Applicant: Frank DiDuro, F.D.'s Sons Properties LLC Date: Nov. 24, 2014

Address: 94 Skylark Rd
Lot 11, Skylark Commons
C-B-L: 349 - I-005
perm # 2014 - 02545

CHECK-LIST AGAINST ZONING ORDINANCE

Proposed Use/Work - build new 2 story colonial w attached 22x20 garage

DATE: 10/28/14
 REVISION DATE: -
 DRAIN BY: JFD
 SHEET: **A1**

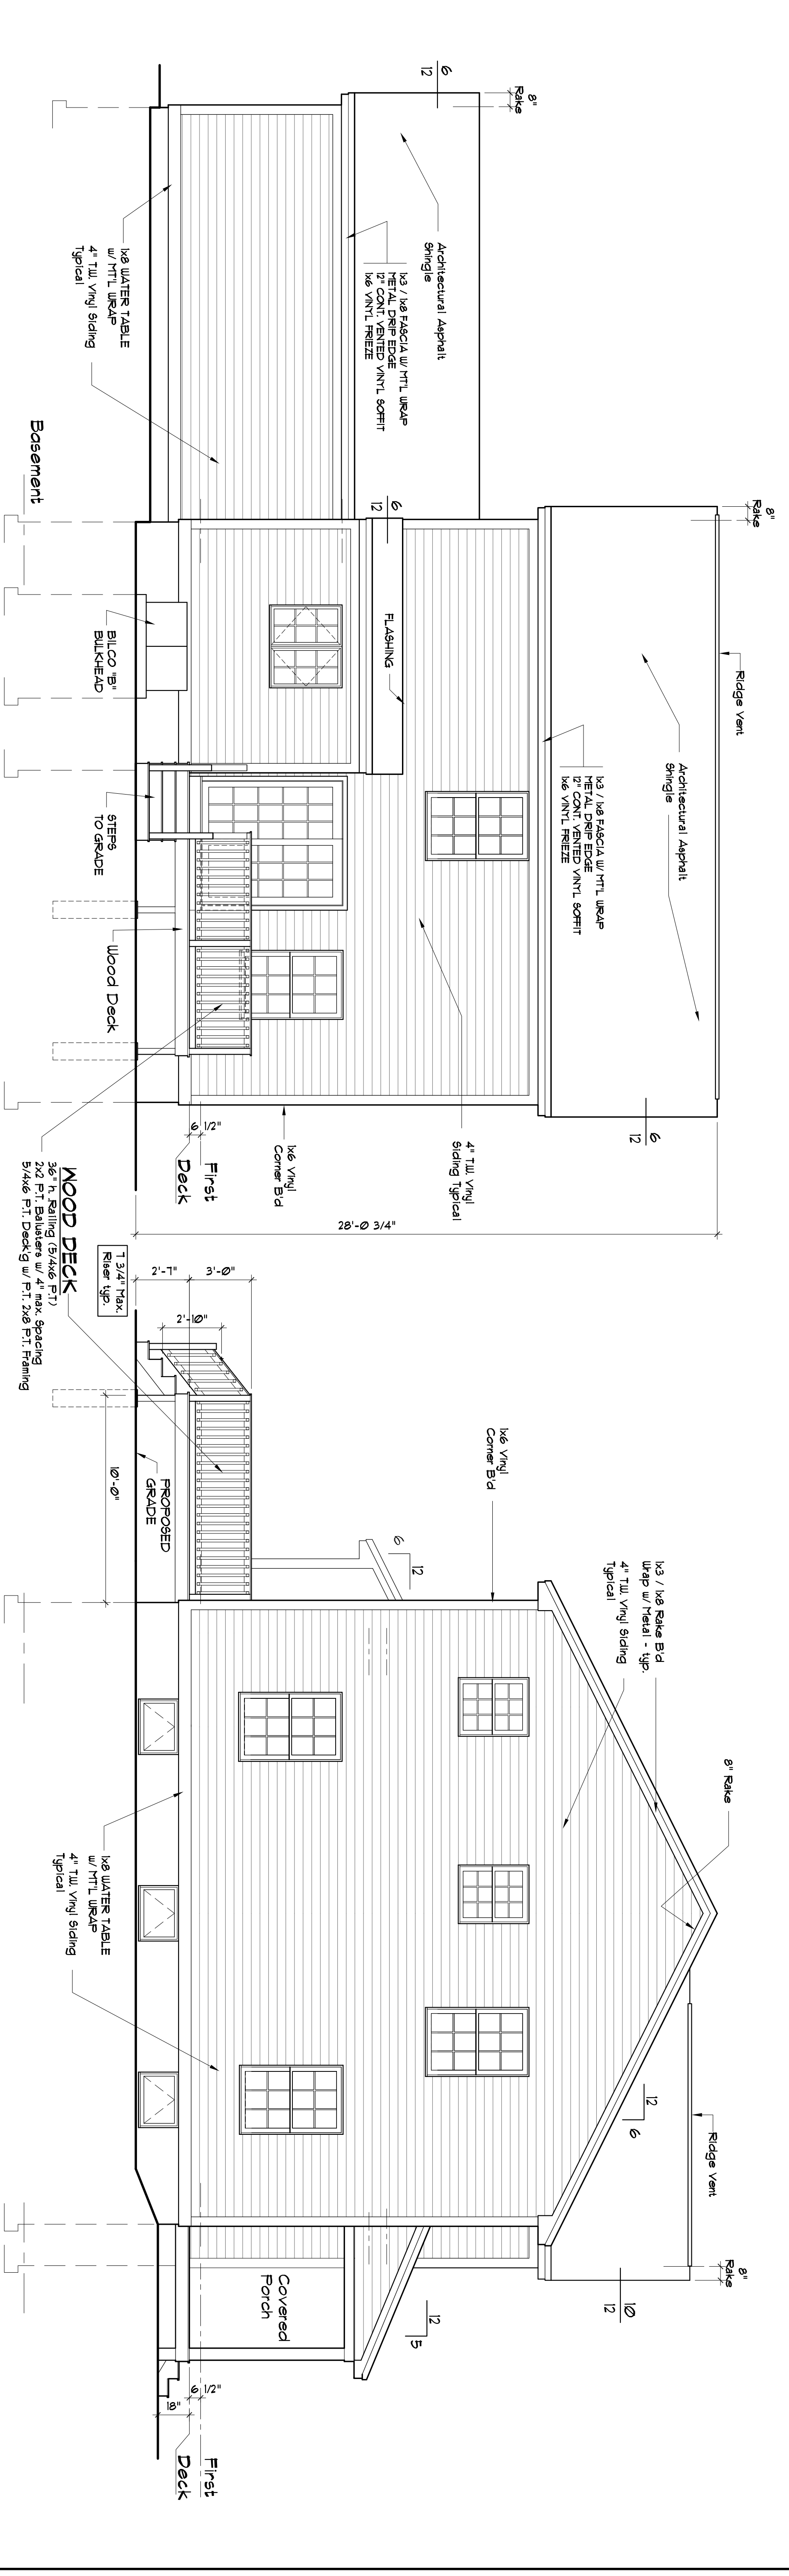
Height - 35' max - 27' g max to ridge (OK)

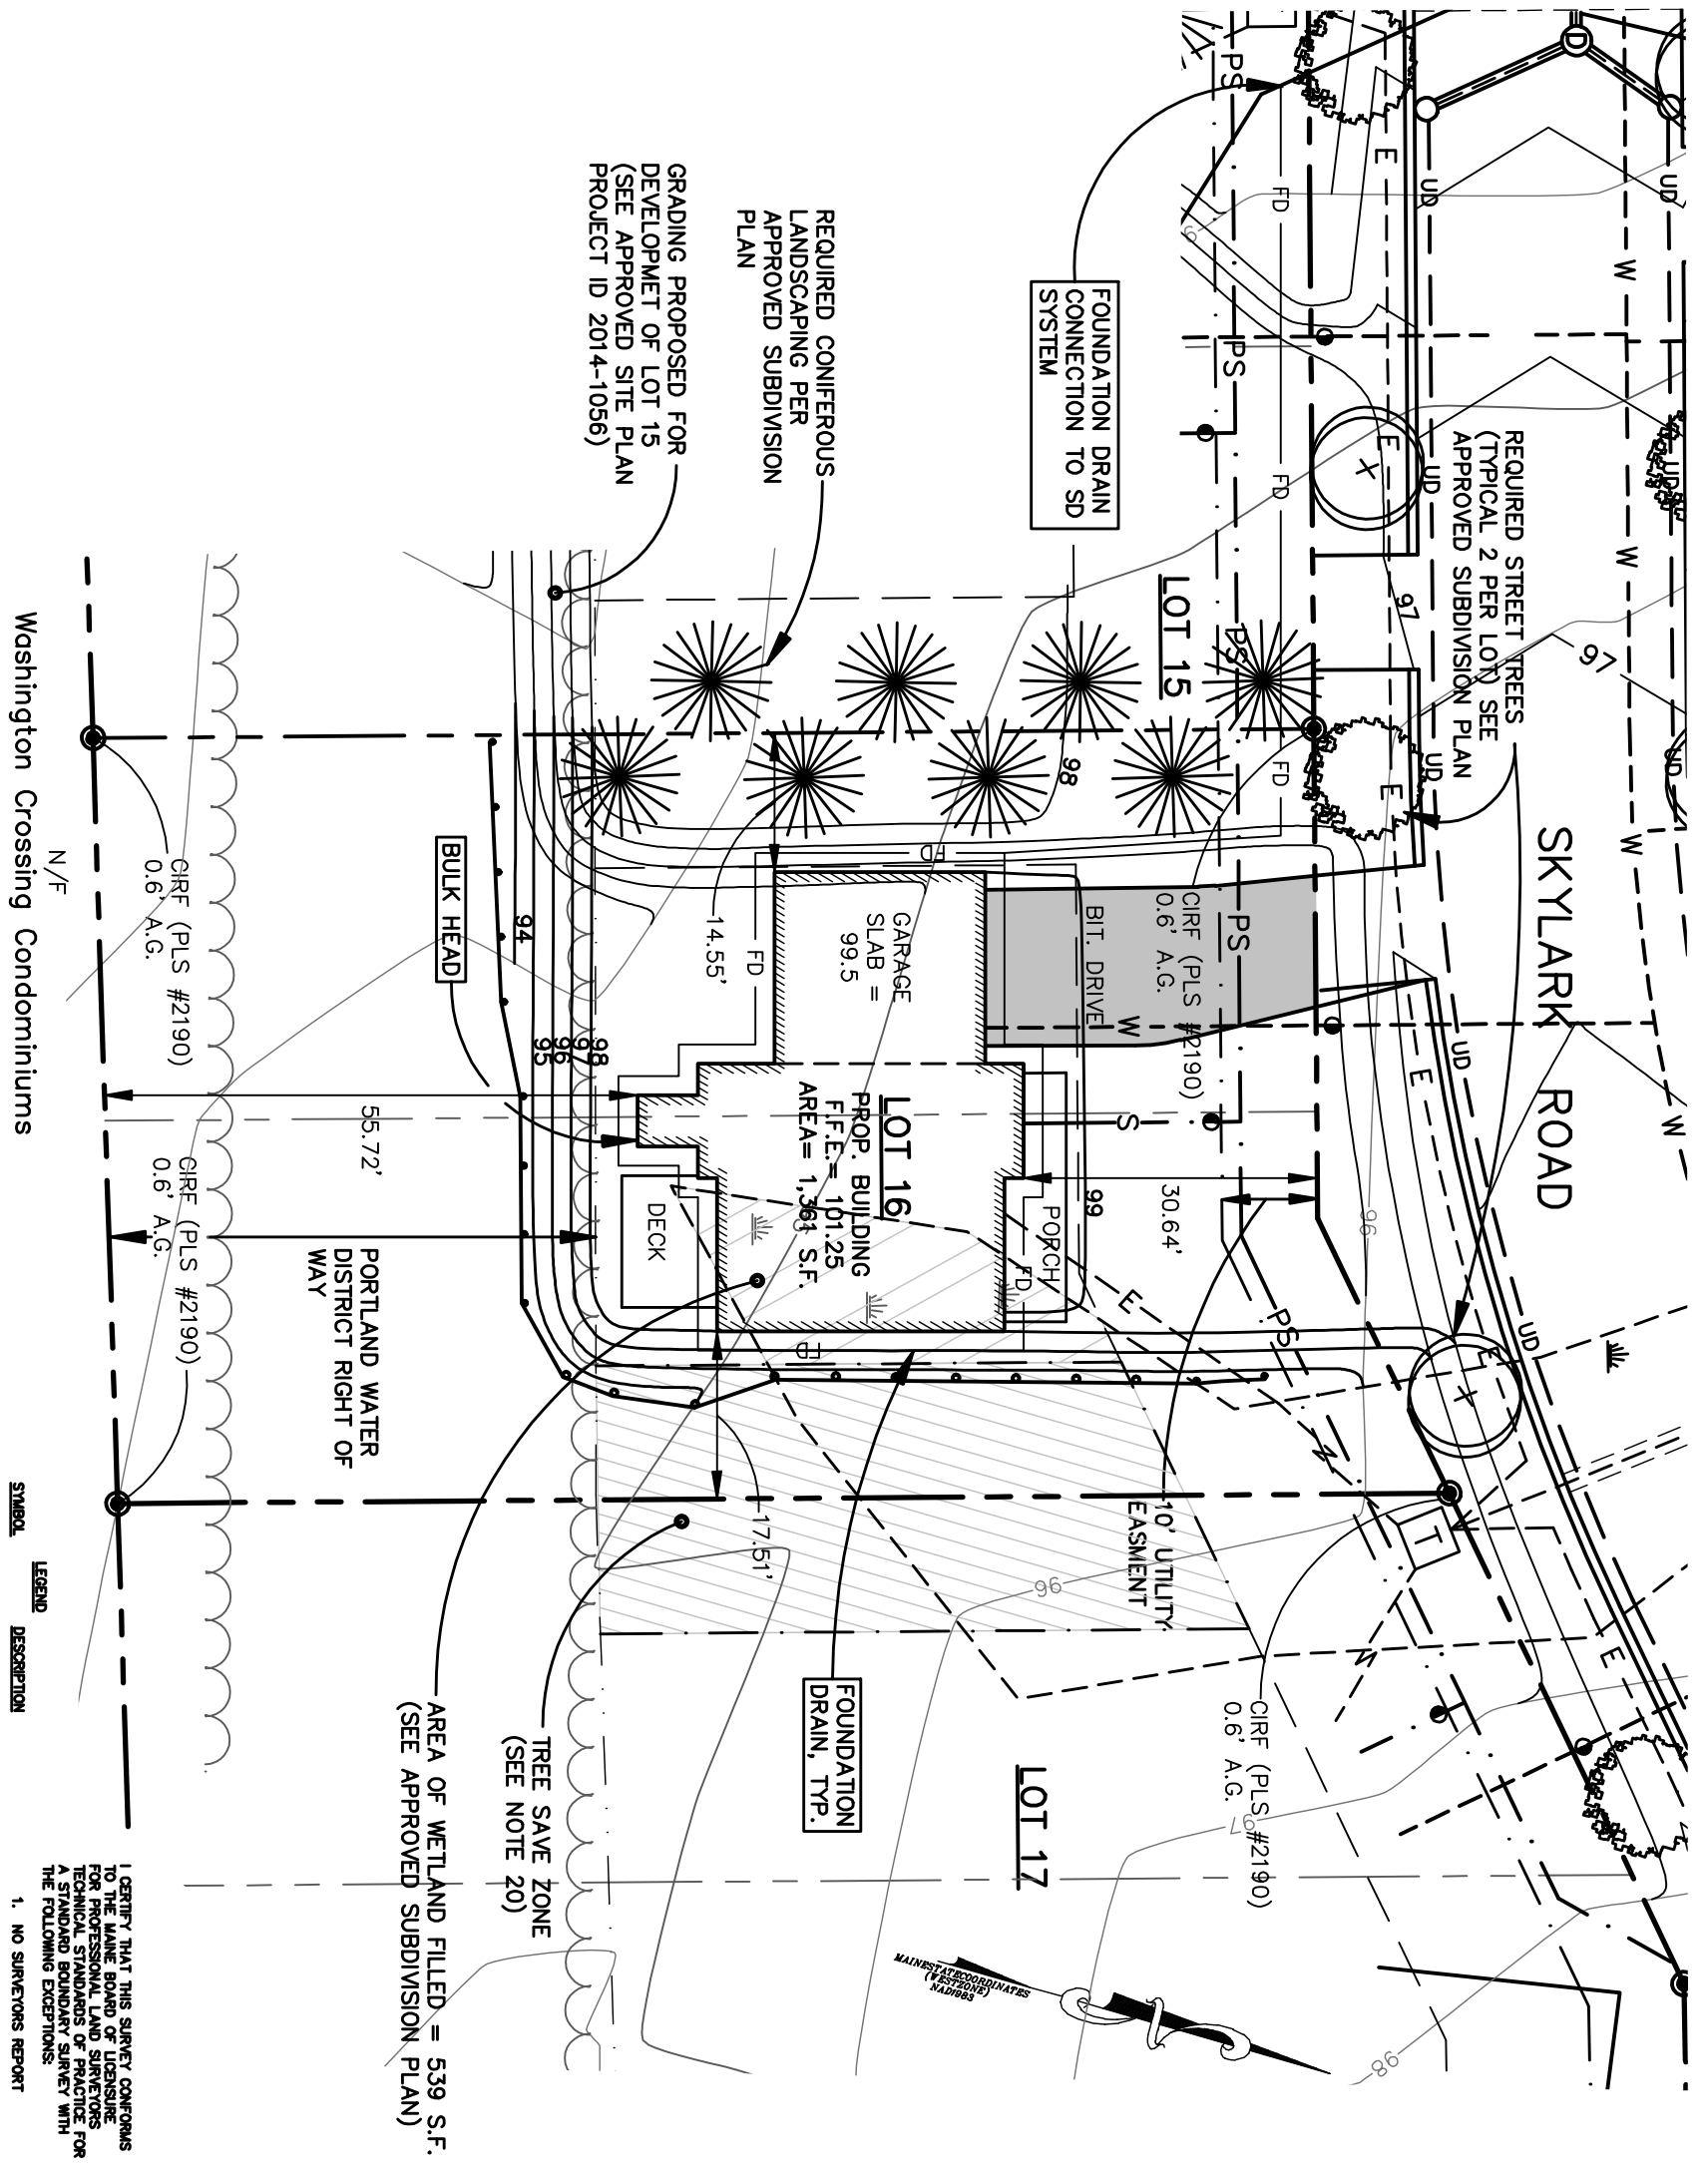
Lot Street Frontage - 50' min - 83.02' on subdivision plat - OK

* Front Yard - 25' min - 26' p porch - 5 steps can't encroach into front set back. (OK) on revised plan 12/16/11

Rear Yard - 25' min - 53.38' rear (OK)

Side Yard - 2 stories - 14' min. - left side - 17.36' scaled (OK)

Projections - — right side - 14.51' 6 min (OK)

Width of Lot - 65' min - 60' scaled (OK)

Lot Area - 6500 sq ft min - 10,327 sq ft min (OK)
